Application no: **3/2021/0841**

Address: **Unit2 and Unit 2a (Pendle Mill) Mill Lane Gisburn BB7 4LN**

Proposal: **Proposed change of use from B8 (Storage/Distribution) to B2 (General Industry).**

The Local Highway Authority have viewed the plans and highway related documents and have the following comments to make:

CHANGE OF USE B8-B2
PENDLE MILL, OFF MILL LANE, GIBBURN BB7 4LN
SITE PLAN AS PROPOSED

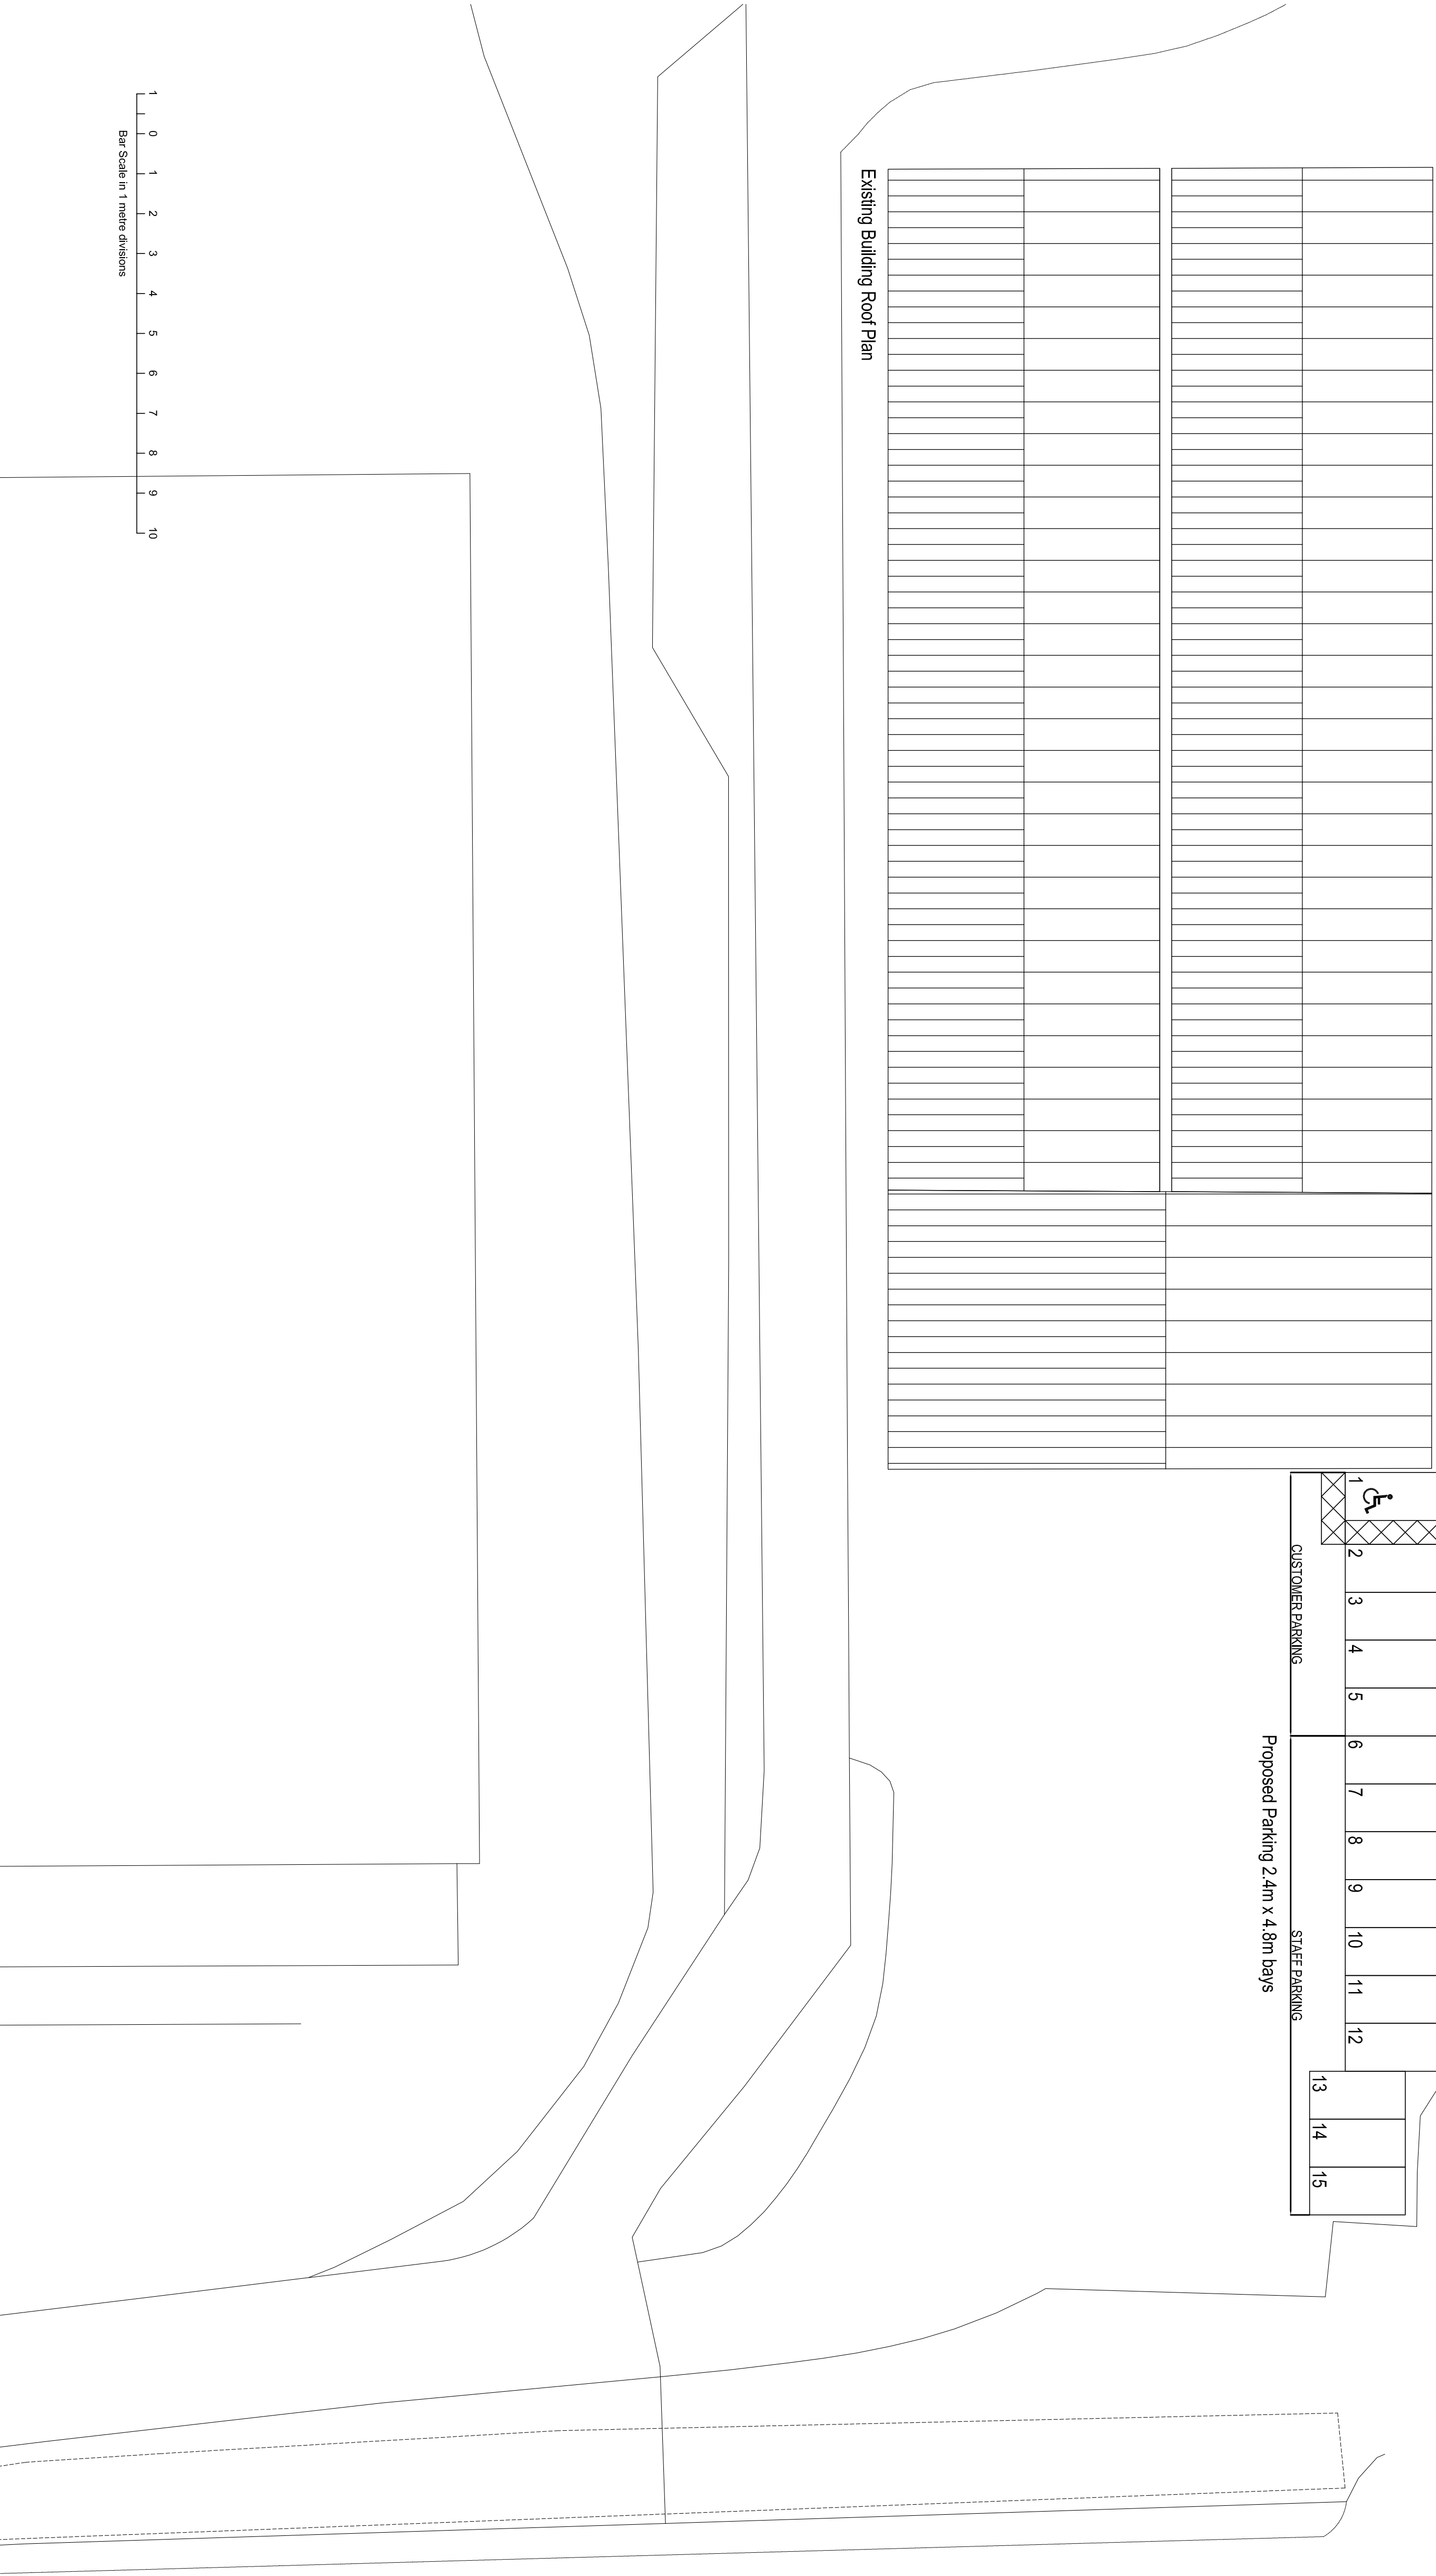
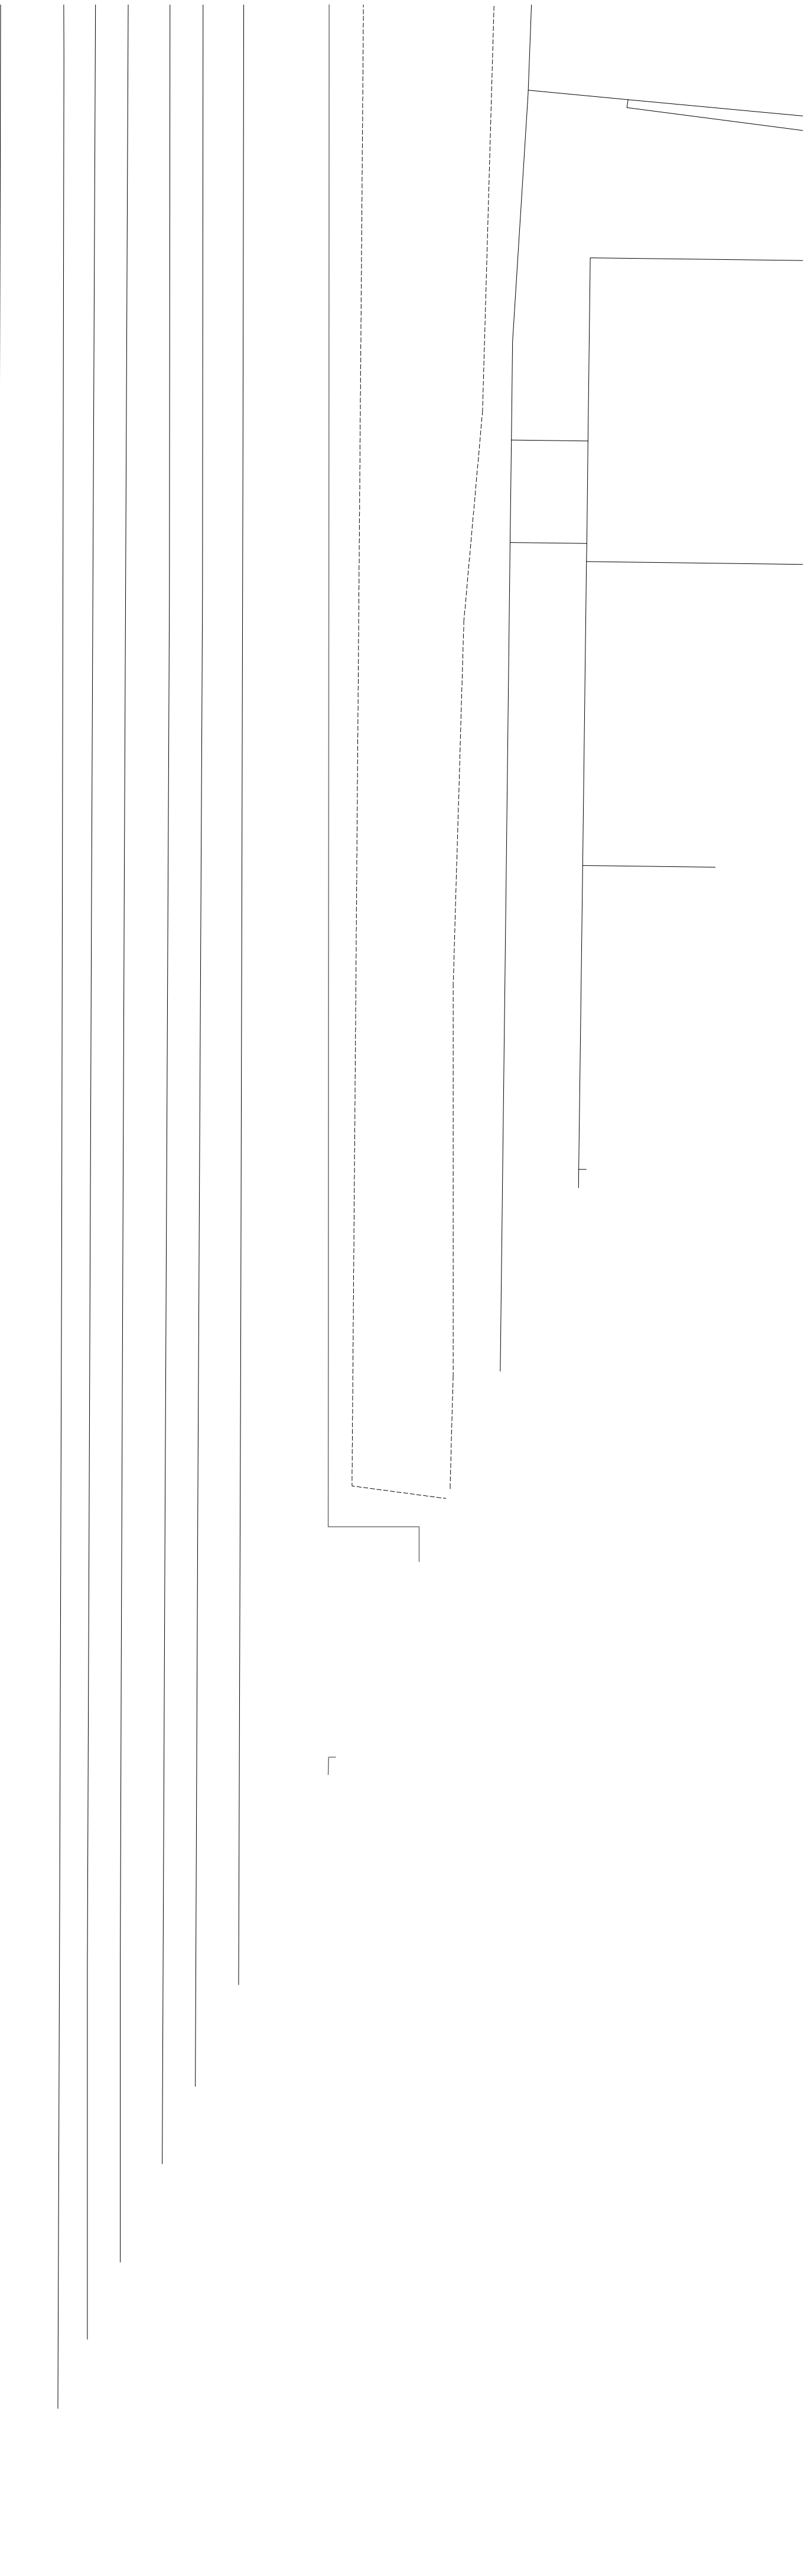
The LHA have reviewed the Operation Statement and understands that the internal floor area of the site is 2117 square meters. For a B2 development, with the same floor area the LHA require 47 car parking spaces to be provided for the proposal to comply with the Joint Lancashire Structure Plan.

However, as shown on IP drawing number 6 titled "Site Plan as Proposed" the site will provide 15 car parking spaces. Therefore, there is a shortfall in 47 spaces.

Notwithstanding this the LHA will accept the shortfall in parking. This is because in the previous highway comments dated 30th September 2021, the LHA stated that if the site provides a similar number of car parking spaces as the existing site where Weldsmart Ltd is based, which is the Applicant as stated in the Planning Statement, the LHA will accept the shortfall.

The Applicant, as a result, has stated in the Operation Statement, that the existing site in Nelson only provides 10 car parking spaces. Therefore, should the proposal be approved, there will be an increase in 5 car parking spaces in comparison to the existing site and so the LHA will accept the shortfall in parking.

It is also worth noting that the LHA will condition that the site has access to cycle storage facilities to encourage more cycling to work, especially when 9 of the 17 current employees live in the Ribble Valley area. Therefore, by having access to a secure and sheltered cycle storage facility on site it is likely to encourage more employees to cycle to work along with the one of the current employees, as stated in the Operation Statement.

1. The development hereby permitted shall not be occupied until such time as the

parking and turning facilities have been implemented in accordance with IP drawing number 6. Thereafter the onsite parking provision shall be so maintained in perpetuity.

2. No building or use hereby permitted shall be occupied or the use commenced until the cycle parking provision shown on the approved plans has been completed. The area shall thereafter be kept free of obstruction and available for the parking of cycles only at all times.
